SUBJECT: Engineering Review Comment
Mountain View Electric Association Inc. (MVEA)

Project Name: Mayberry Filing 4 – Final Plat

Project Number: SF2317

Final Plat of  
**MAYBERRY, COLORADO SPRINGS FILING NO. 4**  
 Being a replat of Tract A, MAYBERRY, COLORADO SPRINGS FILING NO. 3  
 Lying the Northeast Quarter of Section 14, Township 14 South, Range 63 West of the 6th Principal Meridian  
 County of El Paso (Unincorporated), State of Colorado

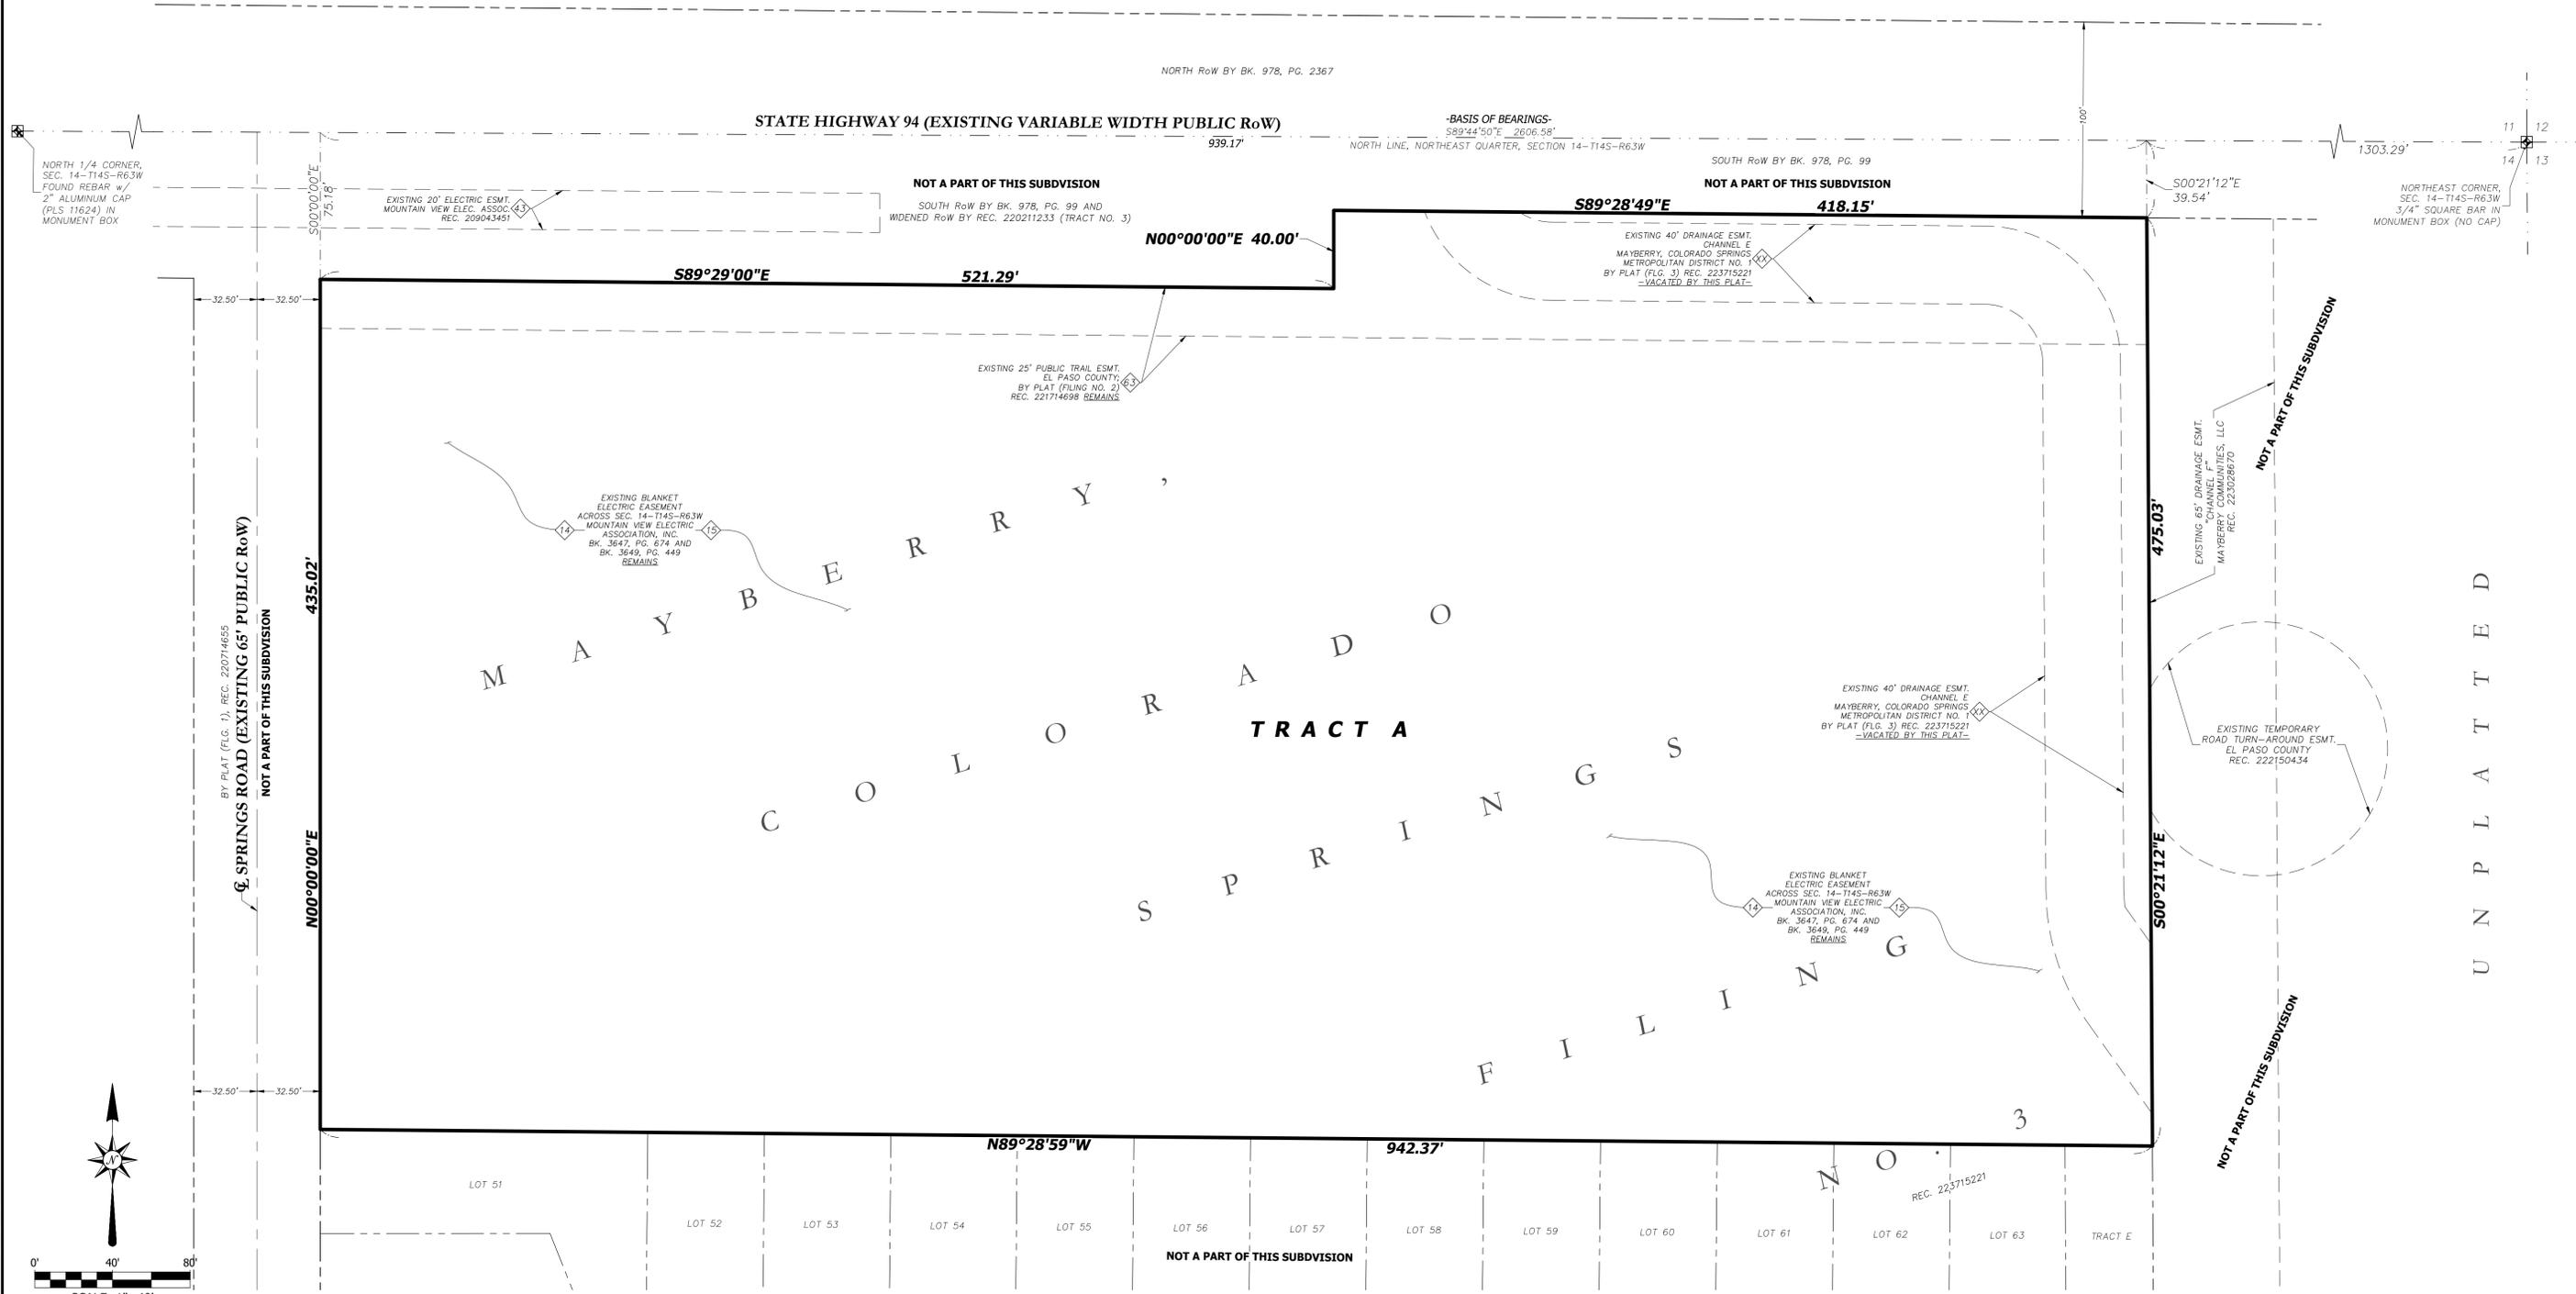
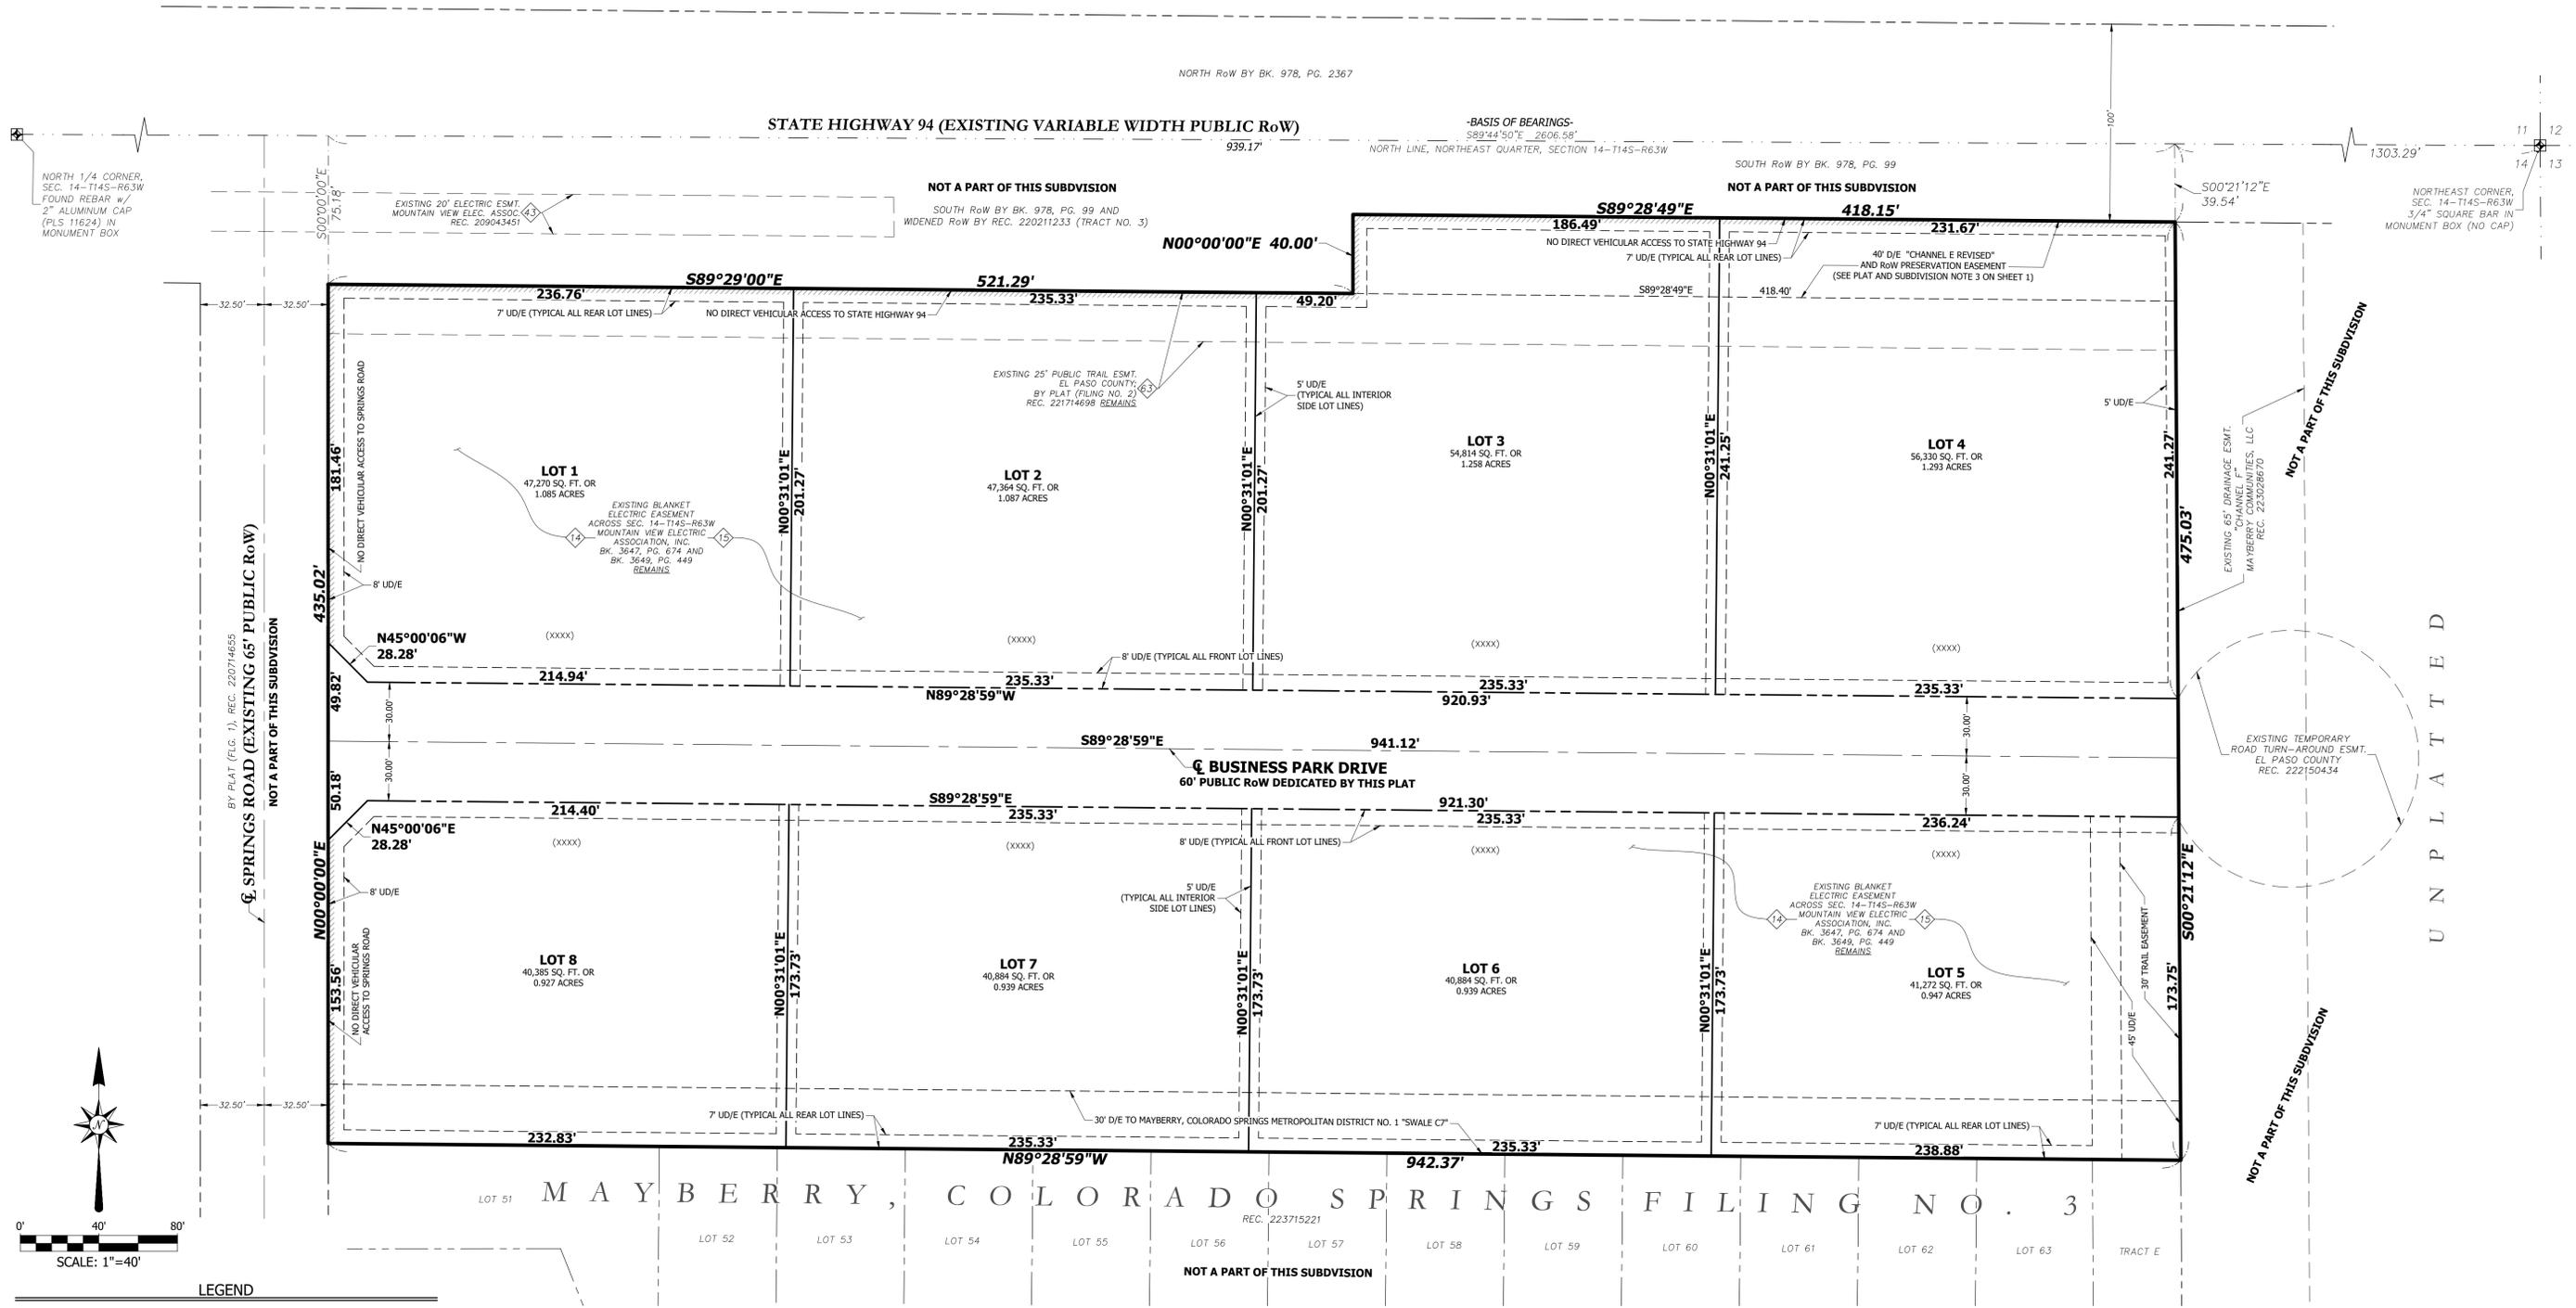
MVEA requests a twenty (20) foot north easement along Highway 94, a seven and a half (7.5) foot either side of the side lot utility easement, and a fifteen (15) foot front and rear lot utility easement along with a fifteen (15) foot boundary easement on the plat and all tracts include easements. MVEA also requests the platting of MVEA's existing facilities with easements on the plat. Additional easements may be required.
